Appendix B – Detailed Response to Submissions and Request for Information

Department of Planning, Industry and Environment (DPIE)

Figure 3 - Proposed OSD & Rainwater Tank Location

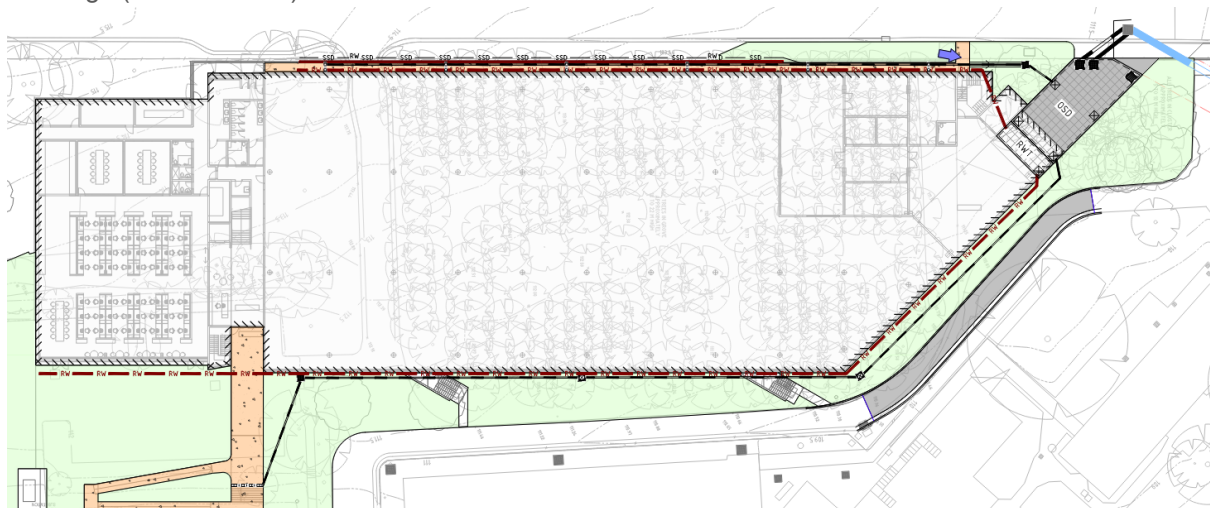
Handbook. a dual orifice design. However, Section 2.4.1 of the report refers to site storage	
HSC9	<p>Further, consideration should be given to the following key OSD tank hydraulic design criteria in the overall design of the tank for satisfactory performance:</p> <ul style="list-style-type: none"> • Downstream tail water levels against proposed tank hydraulic performance to be demonstrated during frequent and major storm events; • OSD tank volume calculation table should be presented in the OSD detail design plans; and • The proposed overland flowpath from the OSD tank ought to be identified towards downstream formal drainage system and to be clearly shown in the design plan as per Trust OSD handbook for implementation. 	<ul style="list-style-type: none"> • Section 2.4.1 of the updated Stormwater Management Report at Appendix K includes reference to how the design was completed to include the effect of downstream tail water levels. • An updated civil drawing identified as DA4.01 is included within Appendix A of the updated Stormwater Report that contains a design summary of OSD tank volume calculations. • An updated civil drawing identified as DA3.02 is included within Appendix A of the updated Stormwater Report that clarifies the proposed overland flow route.

Figure 4 - MUSIC Link and Node Diagram

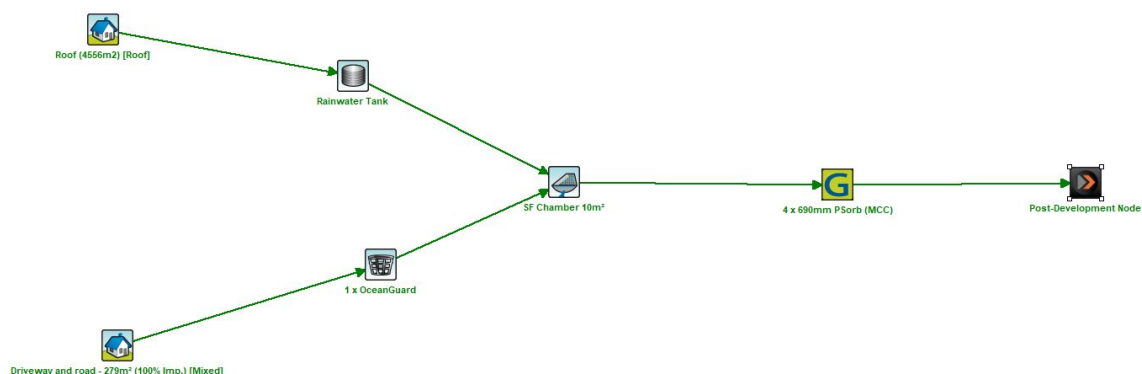
HSC10	Stormwater quality treatment device has been incorporated inside the basin based upon MUSIC model outcomes. It is acknowledged that the MUSIC model analysis utilises BOM Sydney Station (No 66062) rainfall record. Council recommends using Parramatta North (Mason Drive) Station (No 66124), 6 minutes rainfall with modelling period of 10 year duration, given its closer proximity to Council's boundary. This will also ensure greater consistency throughout the Shire.	The updated Stormwater Management Report utilises the recommended Parramatta North station (refer Section 2.5.3 of Appendix K).
HSC11	It is acknowledged that section 7.1.2 of the BDAR considers Option B and raises concerns for the reduction in car parking areas to justify its preference for the proposed development concept. The viability of Option B and alternative ideas of car parking locations or efficiency of the current car parking area design have not been adequately explored or justified within the BDAR. As such, it is considered that avoidance and mitigation requirements of the Biodiversity Assessment Method have not yet been met. The applicant should further investigate options for how the building design and parking	A response to this item is outlined at DPIE5 of this table.

Figure 15 Proposed relocation of TAFE parking spaces

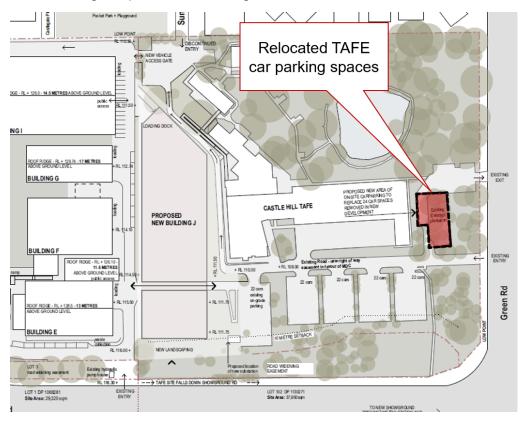
HSC4	<p>The EIS indicates that the 38 informal car parking spaces would be relocated elsewhere throughout the TAFE site to satisfy Condition 2 of the consent for DA 1674/2007/HA. However, no plans have been submitted to identify the</p>	<p>A plan of informal parking spaces to replace the existing informal spaces is included at Appendix M.</p>

Appendix C: Swept Path Analysis

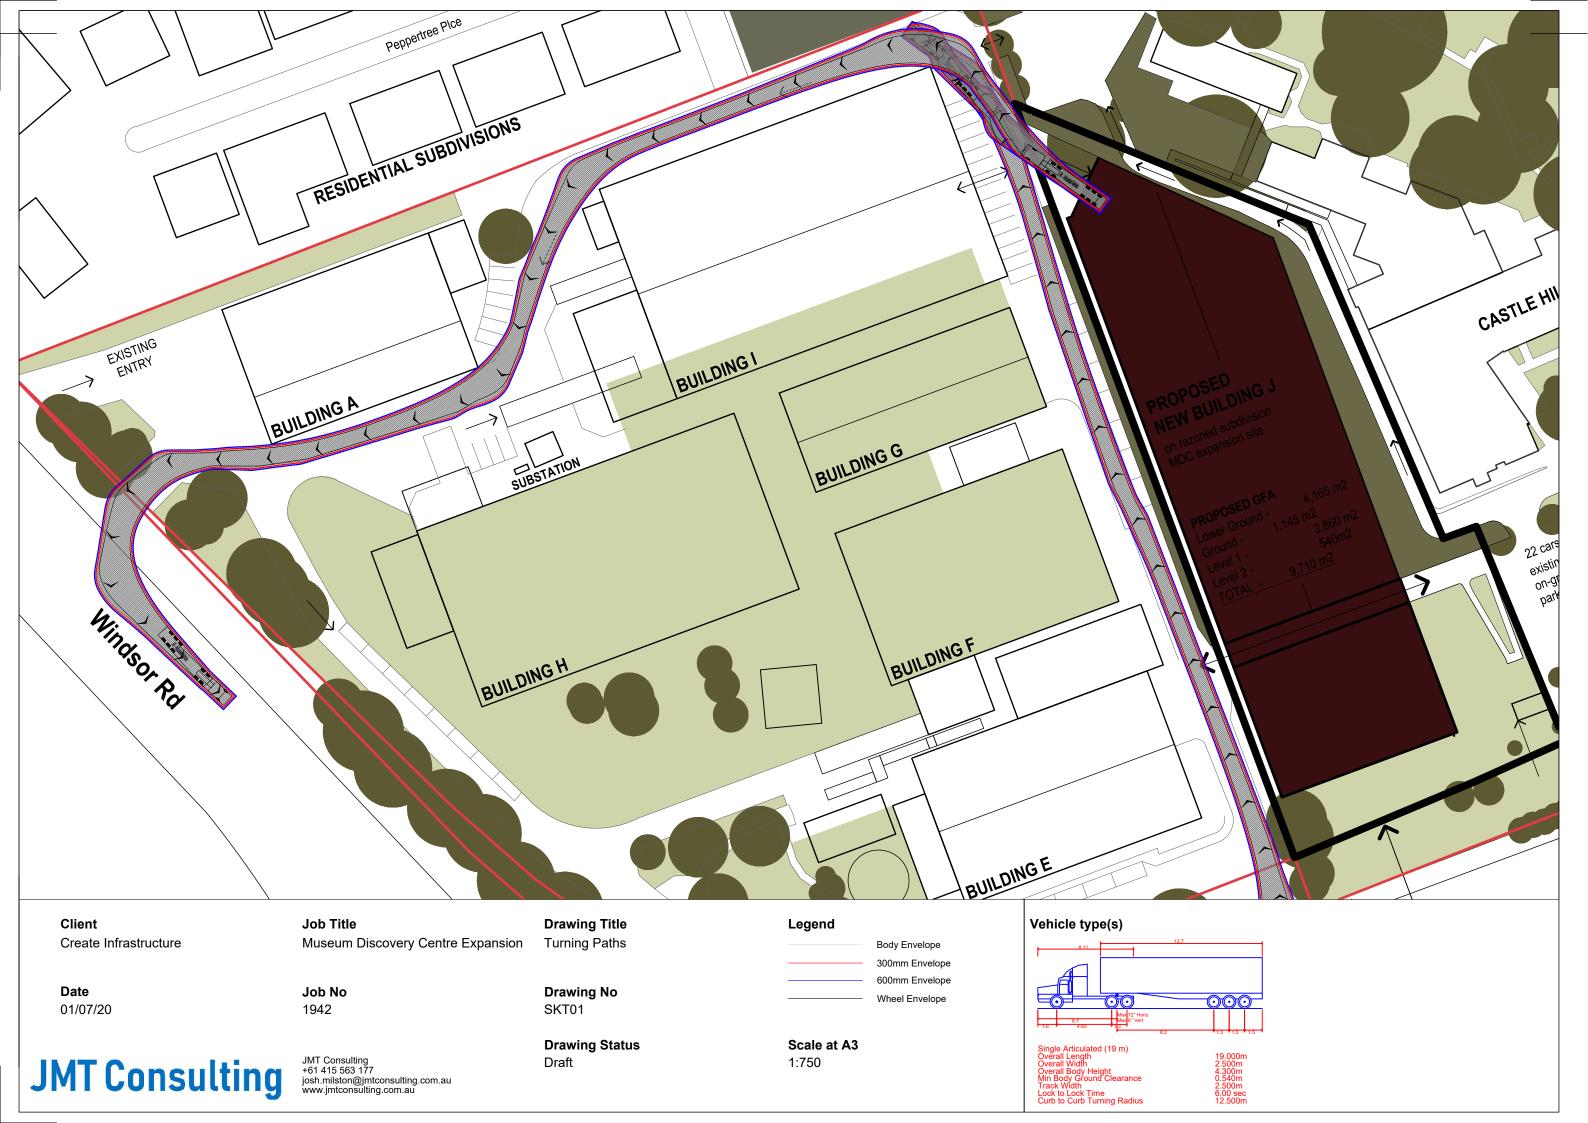
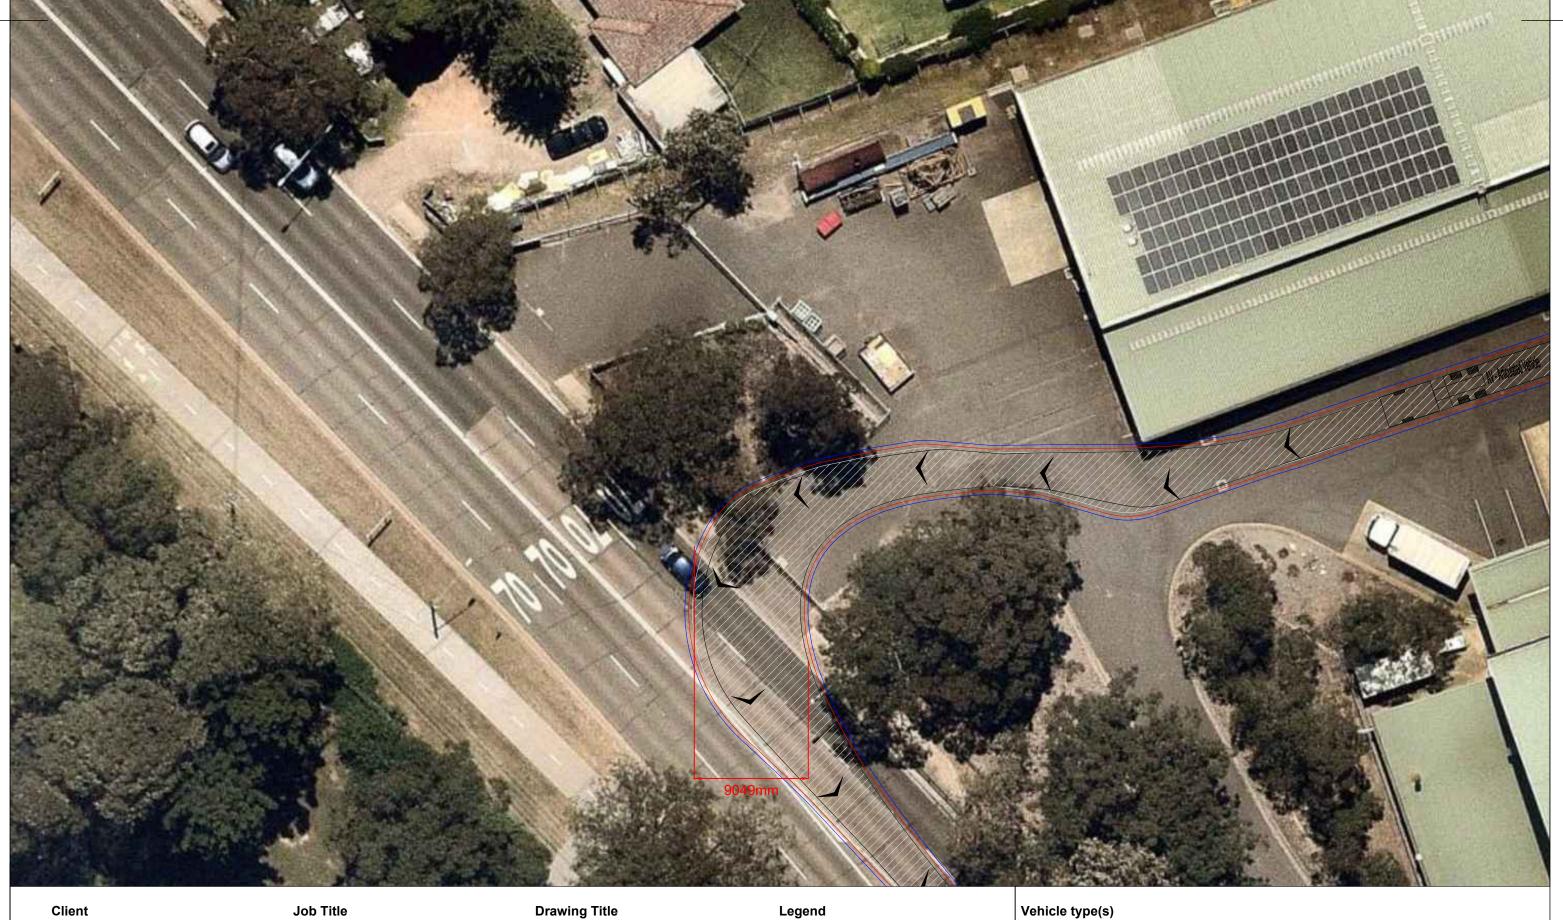
No.	Extract	Response
TNSW1	<p>TfNSW requests scaled swept path analysis showing how the proposed 19m vehicles enter and exit the site from the kerb lanes on Windsor Road and Showground Road. The plans should show the dimensions of the driveways and lane arrangement on both Windsor Road and Showground Road. Please note the submitted swept path diagram does not show this information.</p>	<p>Scaled swept path analysis, using Nearmap aerial imagery, has been provided in Appendix G as part of the updated Transport Impact Assessment supporting the Response to Submissions. The swept path analysis demonstrates that 19m long vehicles can adequately enter the site from Showground Road and exit the site via Windsor Road. This reflects current operations for the MDC site.</p> <p>As per the Clause 28(2) of the NSW Road Rules, vehicles longer than 7.5m (and displaying a do not overtake turning vehicle sign) are permitted to make a left turn straddling an adjacent lane.</p> <p>There is no requirement for vehicles exiting a site to only utilise the kerbside lane. Instead, as is the case currently, heavy vehicles will exit the site via Windsor Road after waiting for an appropriate gap in the traffic before turning into the centre lane.</p> <p>As per TfNSW's request, the dimensions of the driveways have been indicated on the scaled swept path plans.</p>
